Application Ref:	2025/0428			 Ribble Valley Borough Council www.ribblevalley.gov.uk
Date Inspected:	11/07/2025	Site Notice:	19/06/2025	
Officer:	EP			
DELEGATED ITEM FILE REPORT:				REFUSAL

Development Description:	Proposed demolition of conservatory and replacement with a two-storey side extension. Replacement of window with patio doors on the rear elevation and rendering.
Site Address/Location:	Riverside Lodge Sawley Old Brow Sawley BB7 4LF

PROPOSED REAR ELEVATION (4)

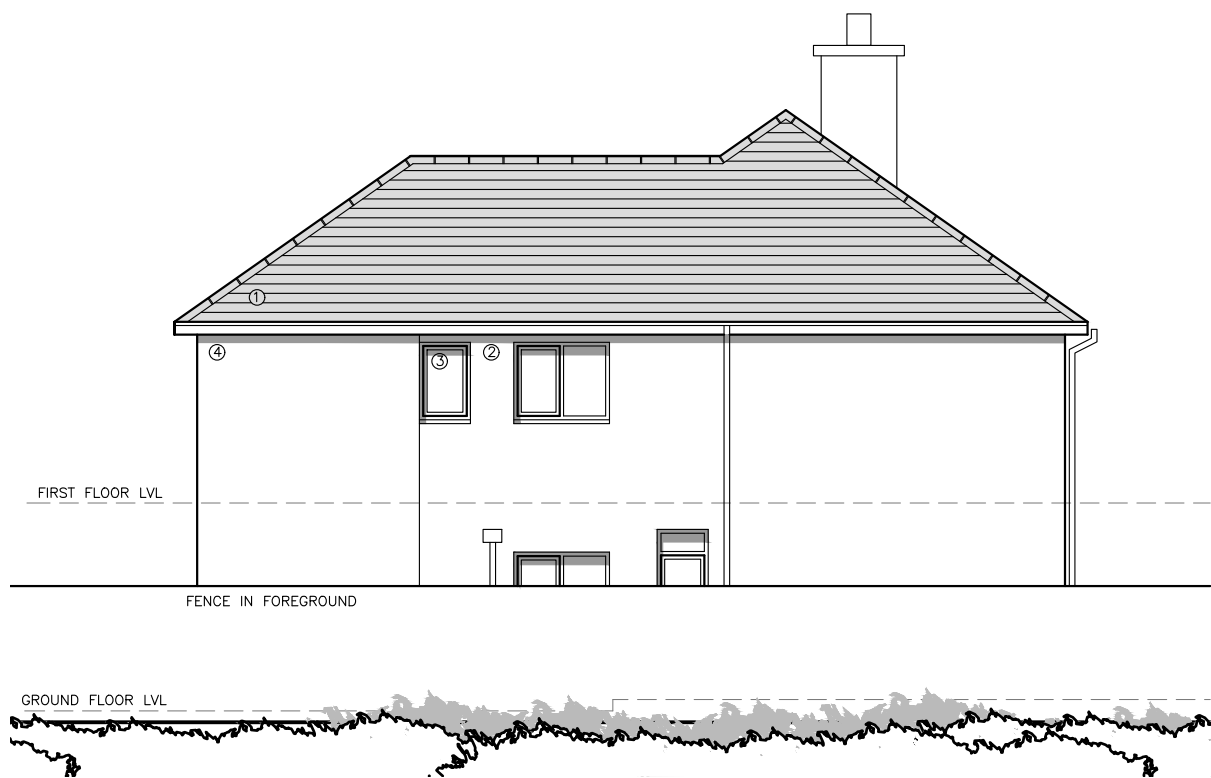
The proposed two-storey side extension would be located to the southwestern side elevation of the dwelling. The proposed extension will sit flush with the existing rear elevation. Given there is no set-back from the rear building line, the extension fails to remain subservient to the host dwelling. It is noted the roof pitch falls below that of the existing dwelling, but given the lack of set-back, this doesn't mitigate the visual dominance. The existing rear elevation and the property's roof profile benefits from a simple, linear formation with a degree of symmetry which contributes positively to the character of the dwelling and wider conservation area. The proposed two-storey extension, with no suitable set-back, will disrupt this simple traditional linear formation and elongate the bulk and massing of the building on this elevation.

Under approved application 3/2025/0428 either side elevation would have retained the red facing brickwork to offset the use of render. However, this application proposes additional rendering and it is considered that an entirely rendered rear elevation, paired with a fully rendered two-storey side extension would result in the development appearing overly prominent within the conservation area and somewhat stark within the street scene by virtue of the increased scale and overall amount of render now proposed. In addition, large sections of glazing are proposed on the rear elevation, including a large Juliet style balcony with glazed sliding doors at first floor. Whilst it is noted that there are large windows and glazed doors on the existing rear elevation, further larger sections of glazing would result in the development appearing incongruous within the street scene, and out of character within the conservation area and wider national landscape, by virtue of a disproportionate void to solid ratio. This is exacerbated by the proposed Juliet balcony at first floor level which would have increased visibility. This large amount of render, paired with the significant amount of glazing, does result in the property appearing overly contemporary within the conservation area of harm to its inherent character.

formation by virtue of an anomalous roof form and lack of set-back and increase in glazing would result in the development appearing stark and out of character within the conservation area and national landscape.

The proposed development would fail to be subservient to the host dwelling and would not be in keeping with its design and appearance, due to the proposed scale and lack of set-back of the two-storey side extension, loss of a linear and symmetrical roof form, dominance of glazing and introduction of additional render. The resultant dwelling would fail to conserve or enhance Sawley Conservation Area and the National Landscape character. This is contrary to Policies DMG1, DMG2 and DME4 and Key Statements EN2 and EN5 of the Ribble Valley Core Strategy and Paragraphs 212 and 215 of the National Planning Policy Framework.
